COUNTY COUNCIL'S RESPONSE TO CONSULTATION ON THE FOLLOWING DEVELOPMENT PROPOSAL

Application No: 20/02779/REM

Proposal: Reserved Matters application to 19/01740/HYBRID - layout, scale, appearance and landscaping details for Phase 1 of the employment development (5,126 sqm GIA), enabling works for later phases and SuDS Swale delivery, with associated landscaping, utilities and access

Location: Land Adj To Promised Land Farm, Wendlebury Road, Chesterton

PHASE 1 - PACKAGE 3
ESTATE ROAD DRAINAGE PLAN

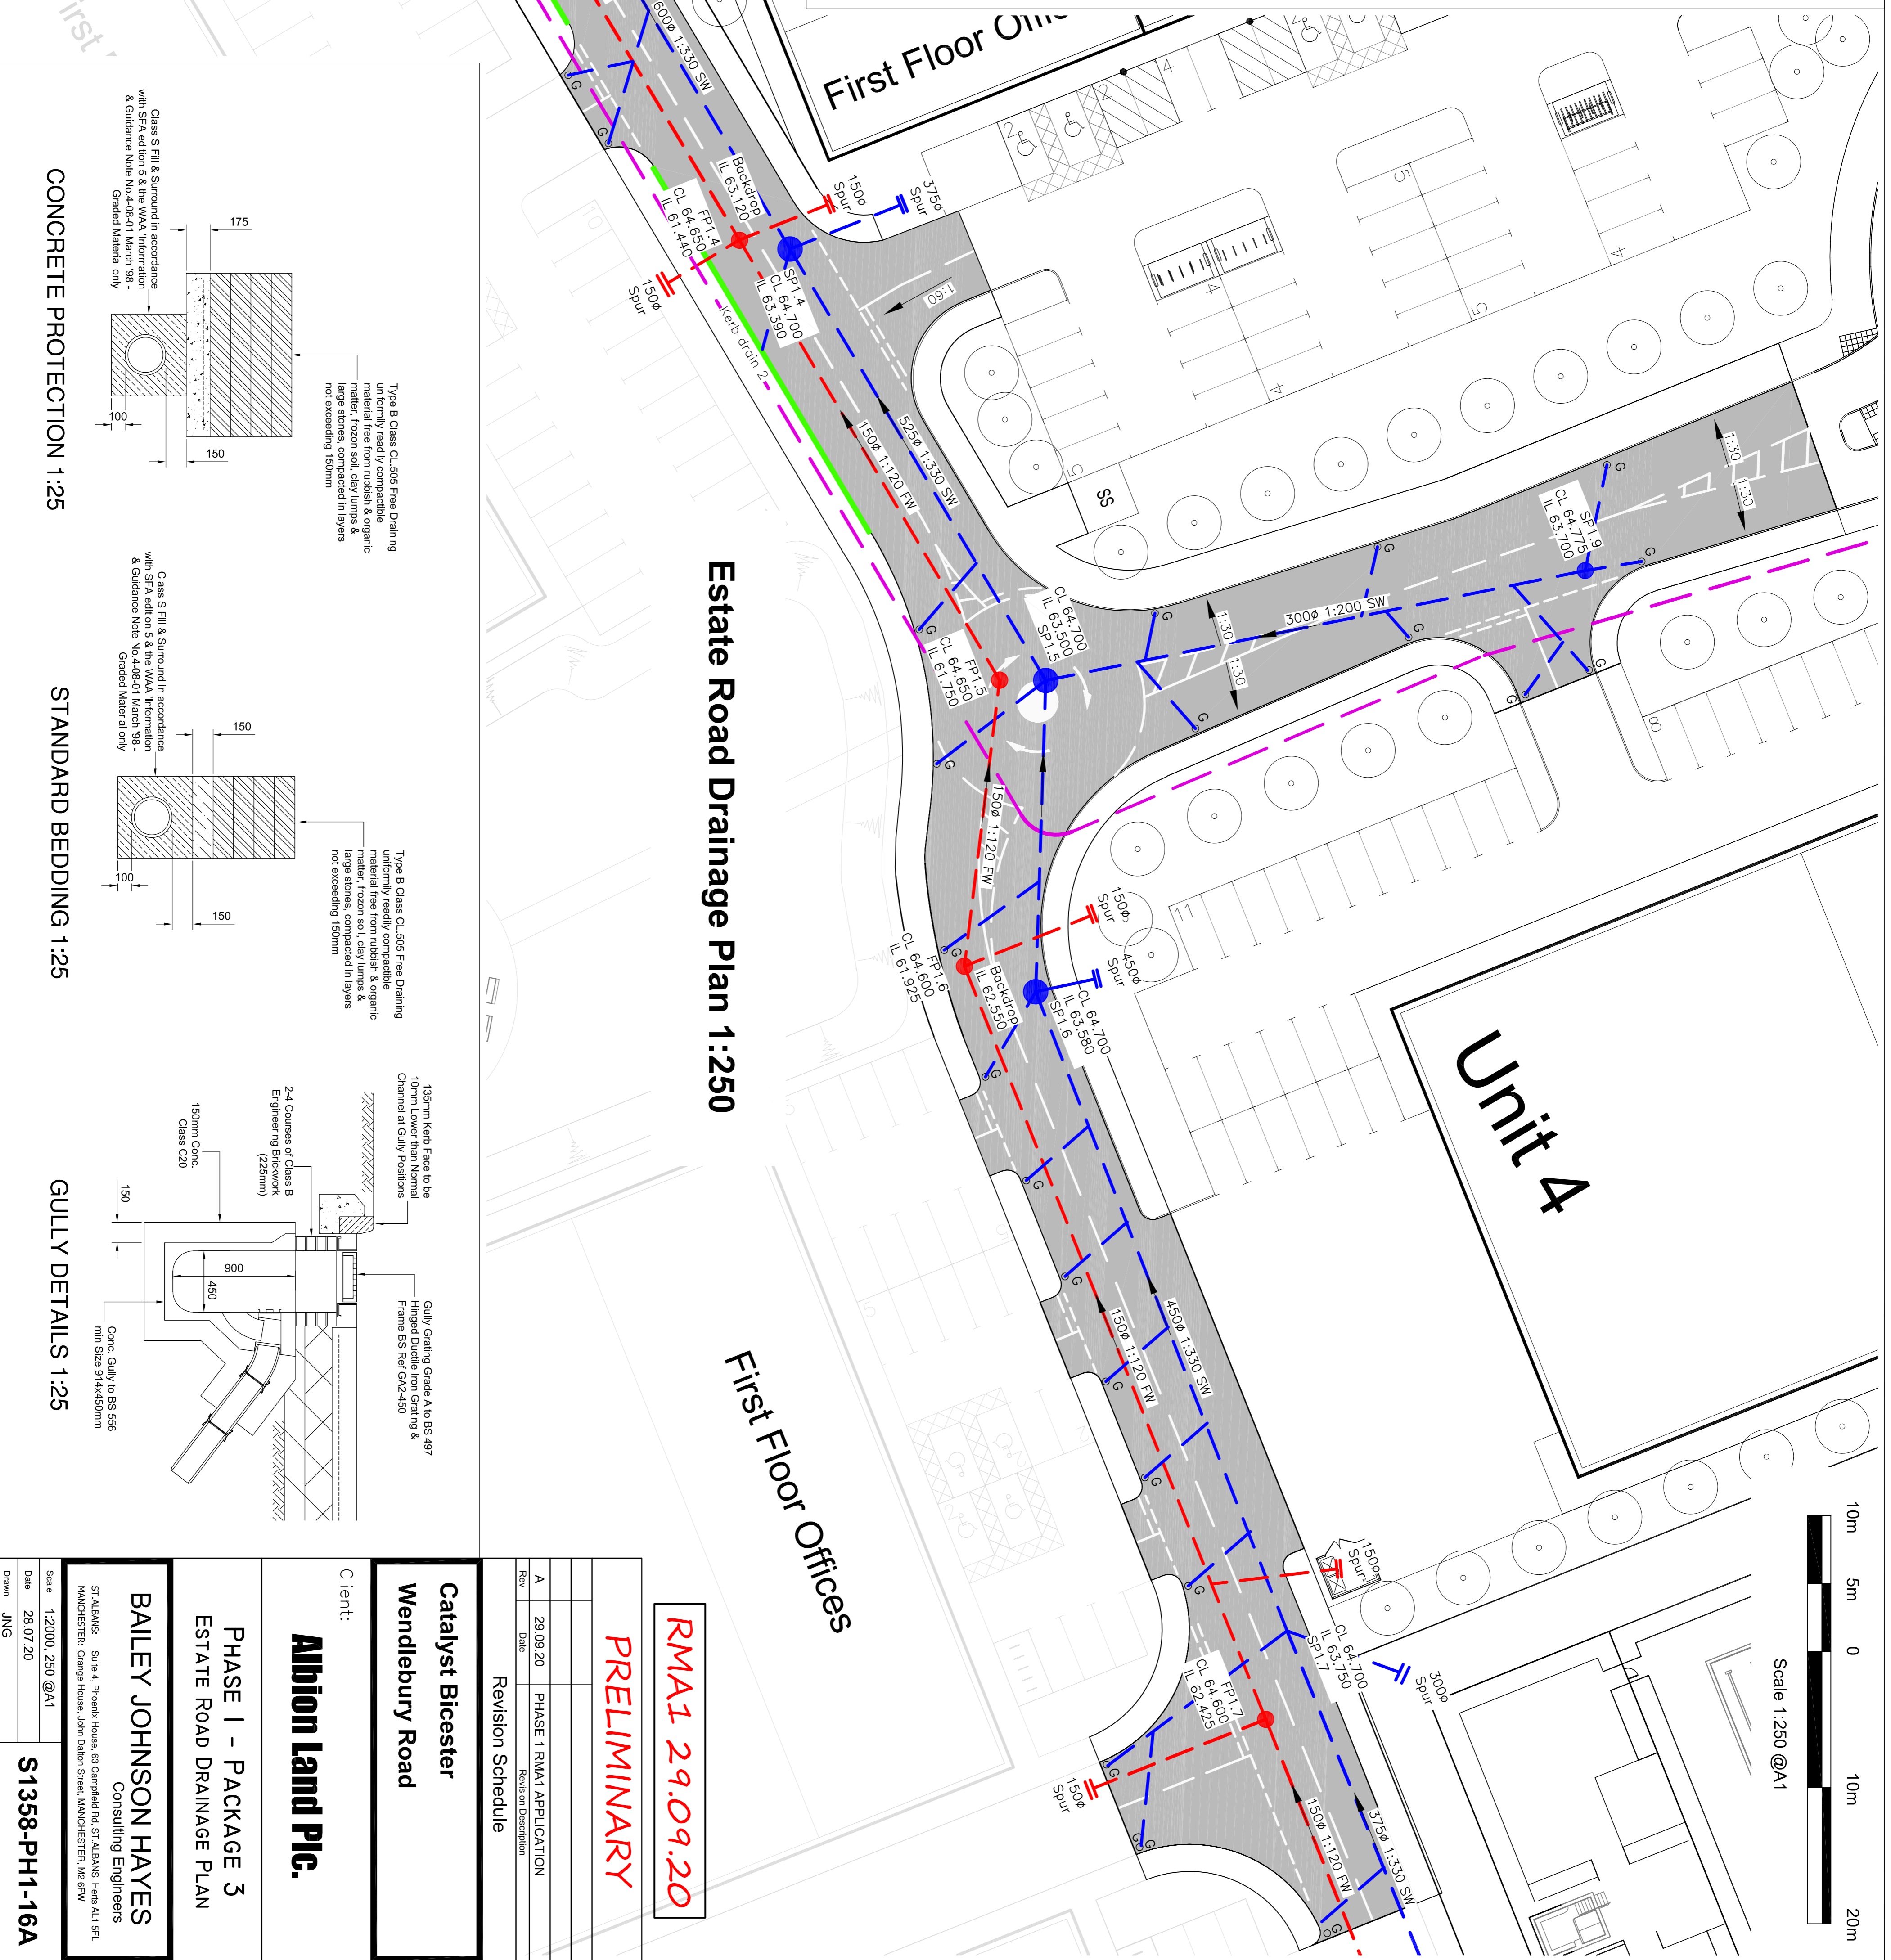
It should be noted, following a Teams meeting with the designers on 20th November 2020, a new surface water drainage design is to be supplied covering the highways drainage element either side of the entrance road to the site.

The design is to remove the need for buried tanking. Reverse flows into the agreed swale and throttle discharge from swale into existing ditchline.

Capacity of this ditchline, running parallel to the road, to accept this discharge is to be confirmed.

PHASE 1 - PACKAGE 3
UNITS 1-3 EXTERNAL WORKS LAYOUT

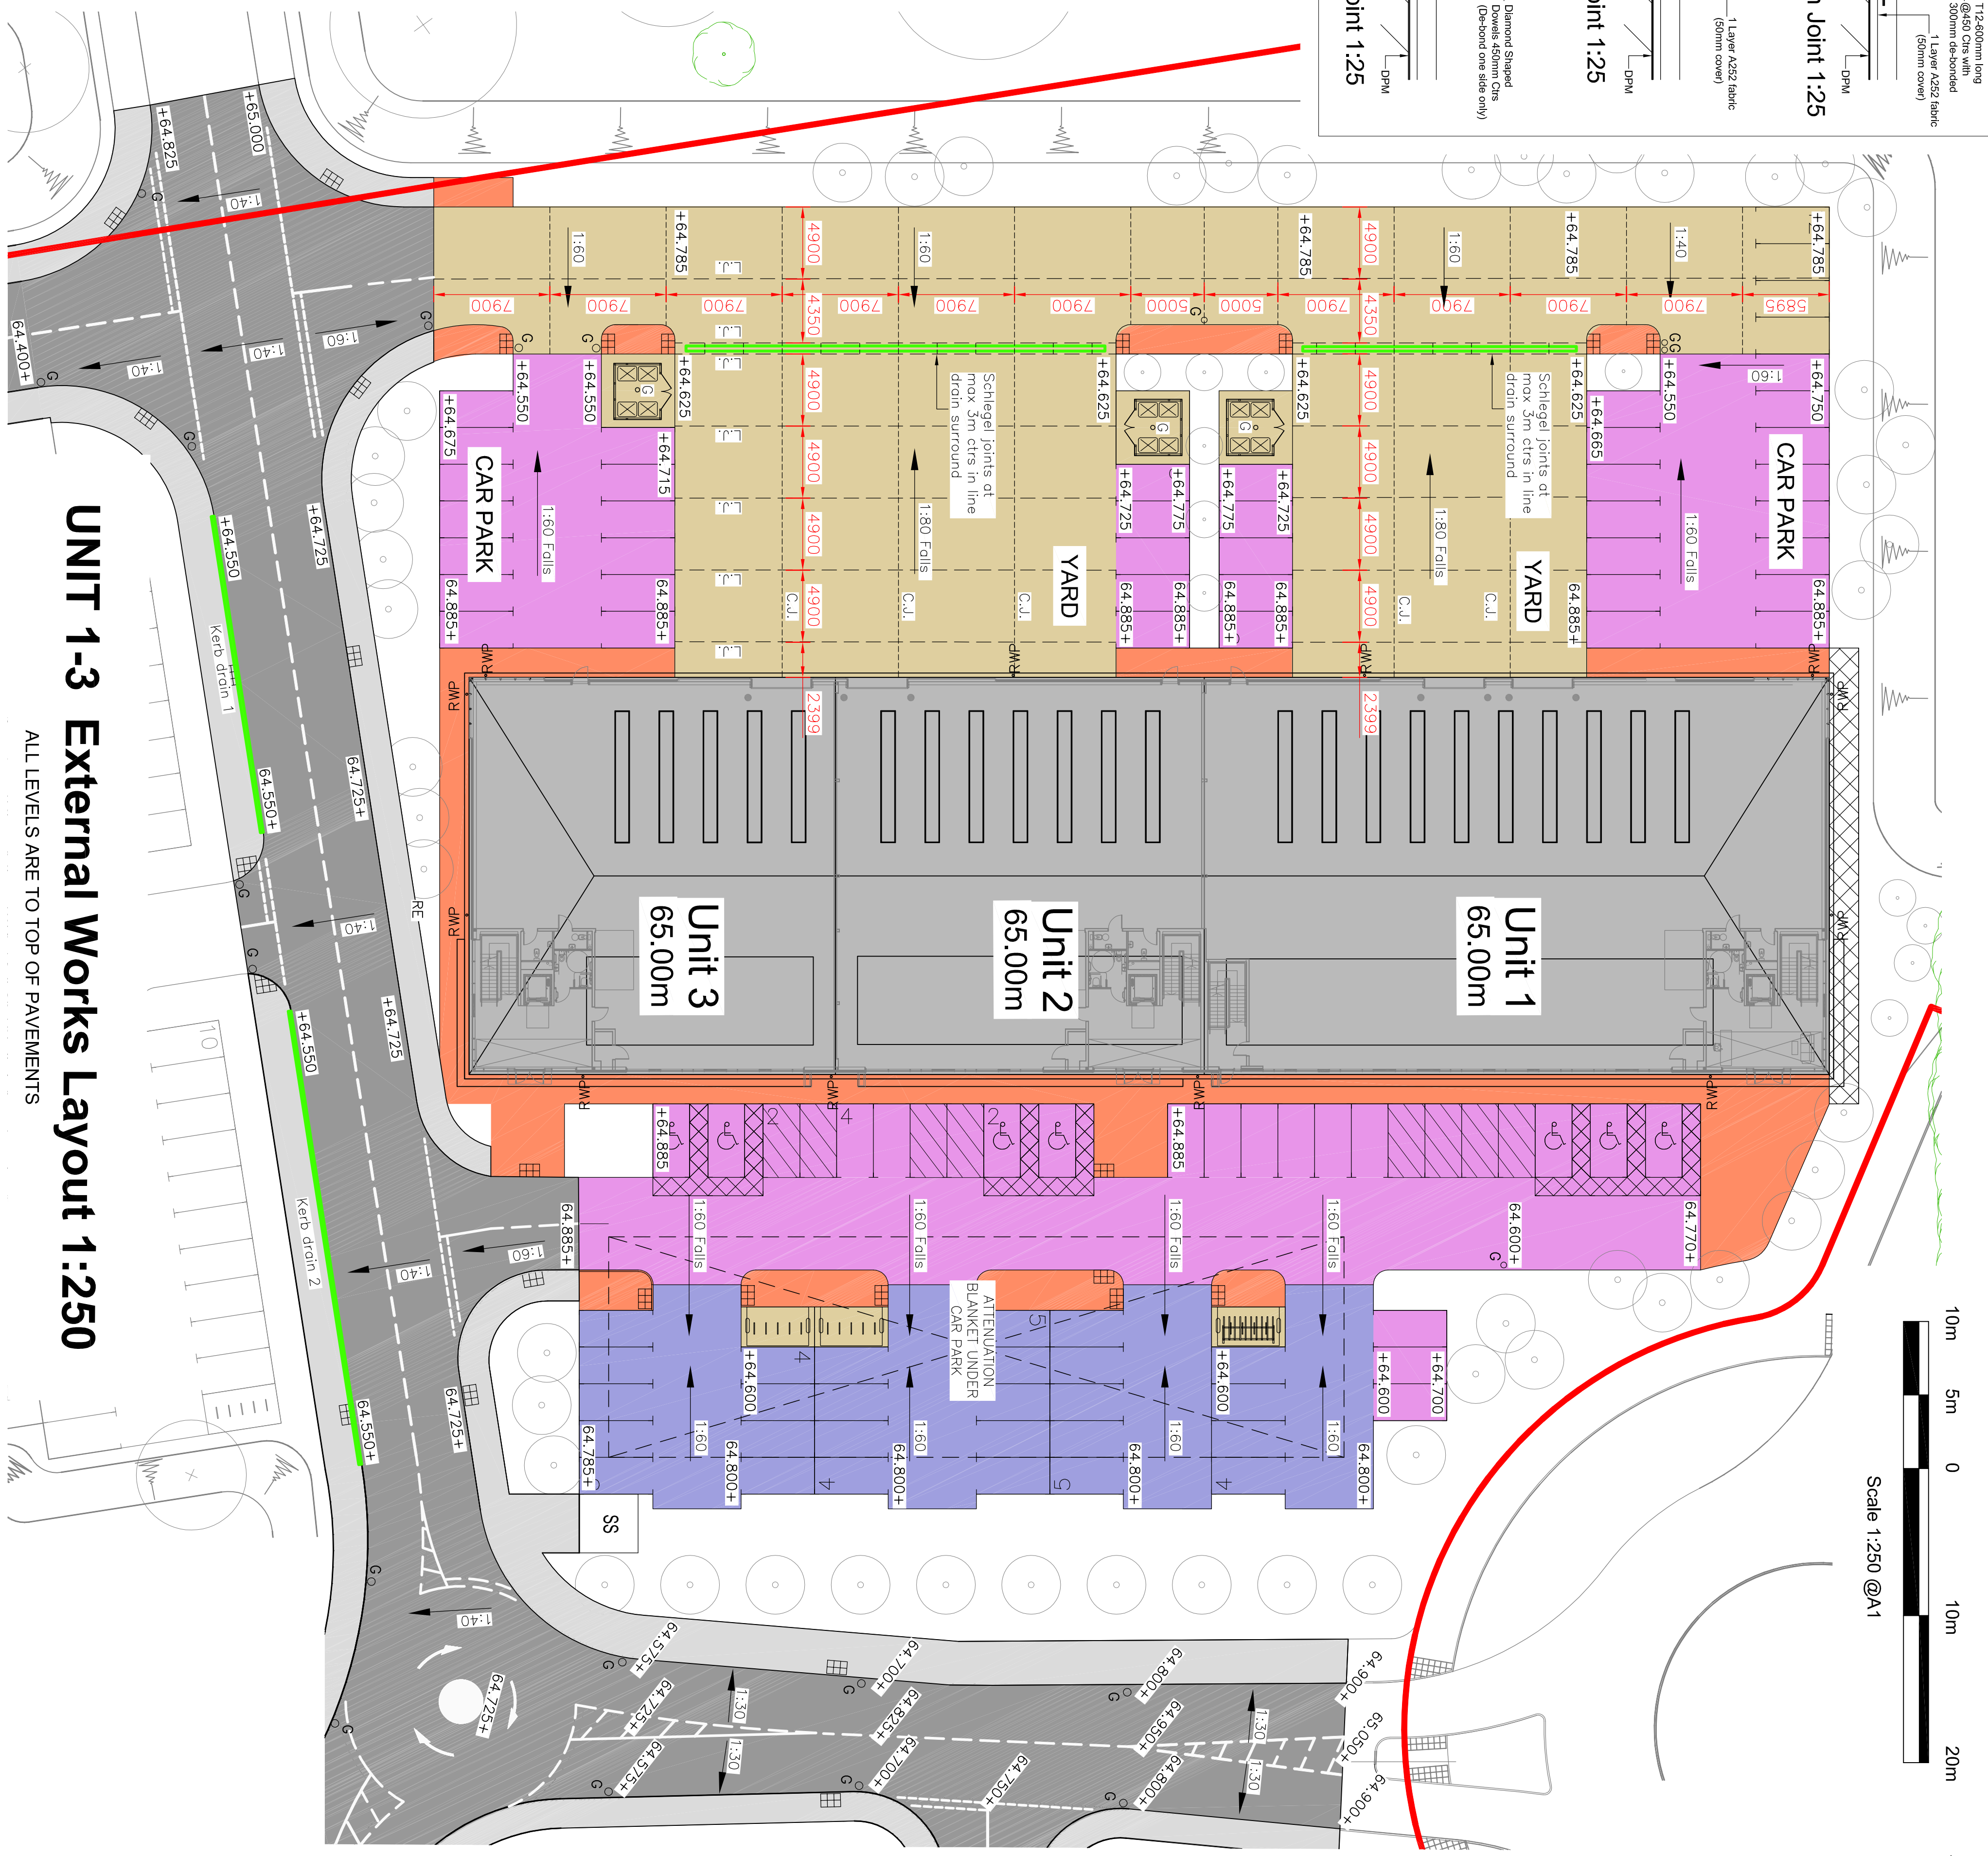
Following on from that, this application has developed a street hierarchy that is more car-centric. Much as a 3m and 2m wide paths have been provided along either side of the estate roads, they offer no directness to front doors. A point in case is how pedestrians are expected to access to Units 1 and 2 where they shall follow the path along alignment of the estate road into the site then back onto themselves. Rather than this, I recommend that provision of a cut through pedestrian only access across the landscape/parking is made for directness. (see below)
